Our Ref: FP/227/14/T
Your Ref:

Town & Country Planning Act 1990 (as amended)
Town & Country Planning (Tree Preservation) (England) Regulations 2012
Application for Works to Tree(s) on trees subject to a Tree Preservation Order (TPO)

Development Various Tree Surgery
Location The Green The Ridgeway Felpham Beach Estate Felpham

Location of trees

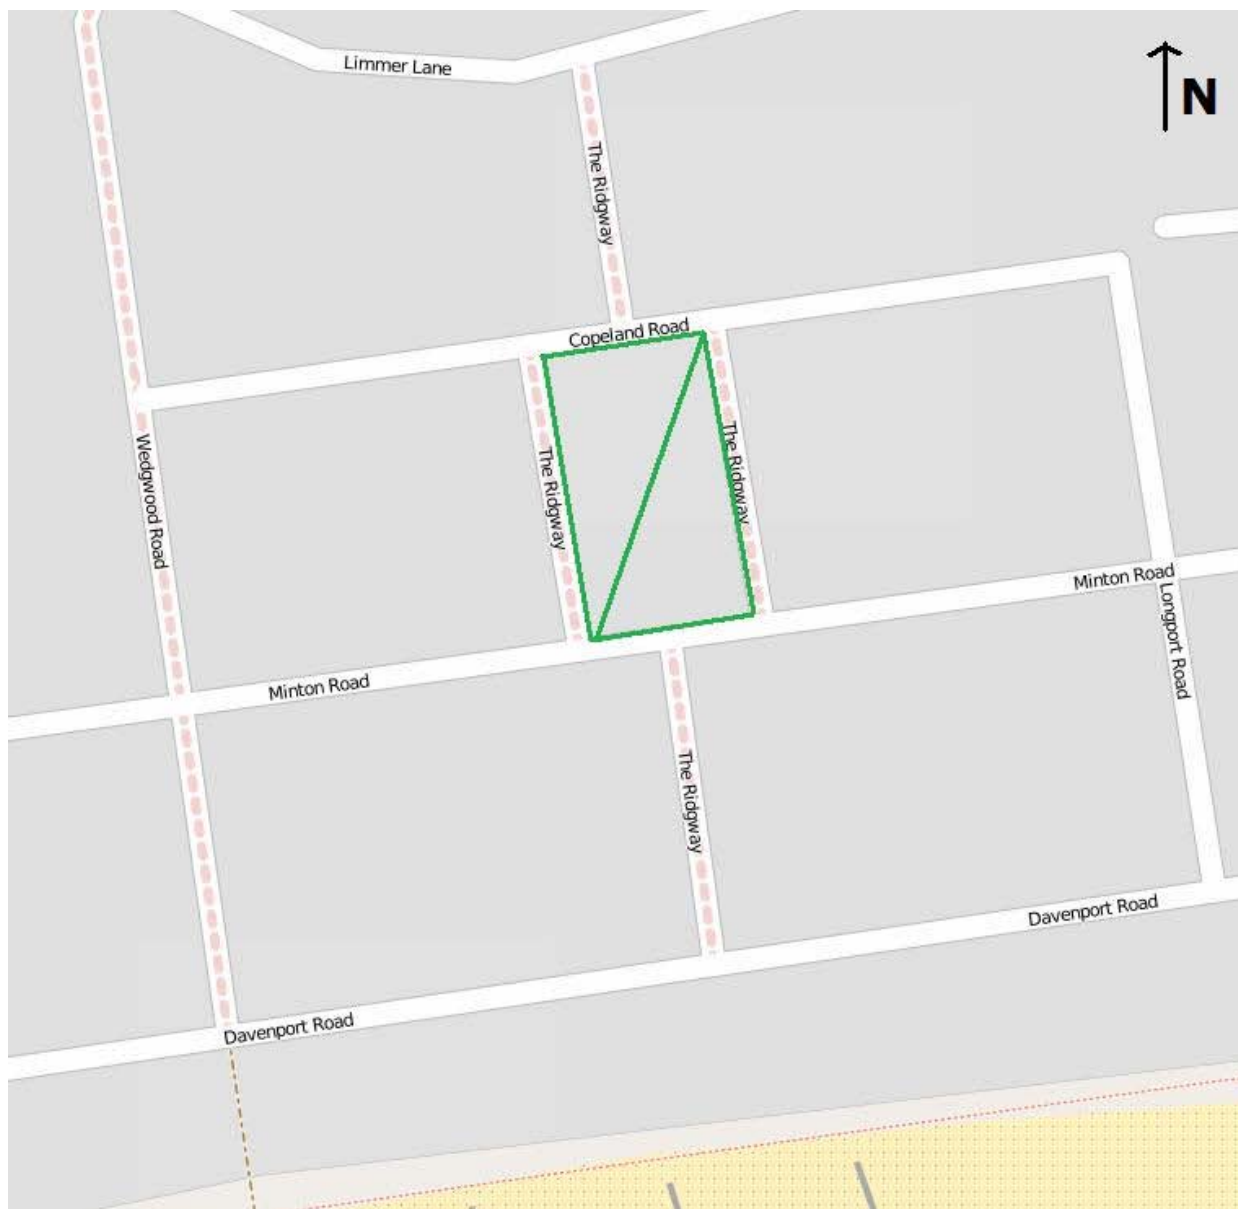
Please submit 1 electronic or 3 paper copies of an amended Location plan to include the road names and the direction of north to allow us to identify the trees against the plan on the Preservation Order.

Please confirm the Location of the trees is correct as shown on this letter.
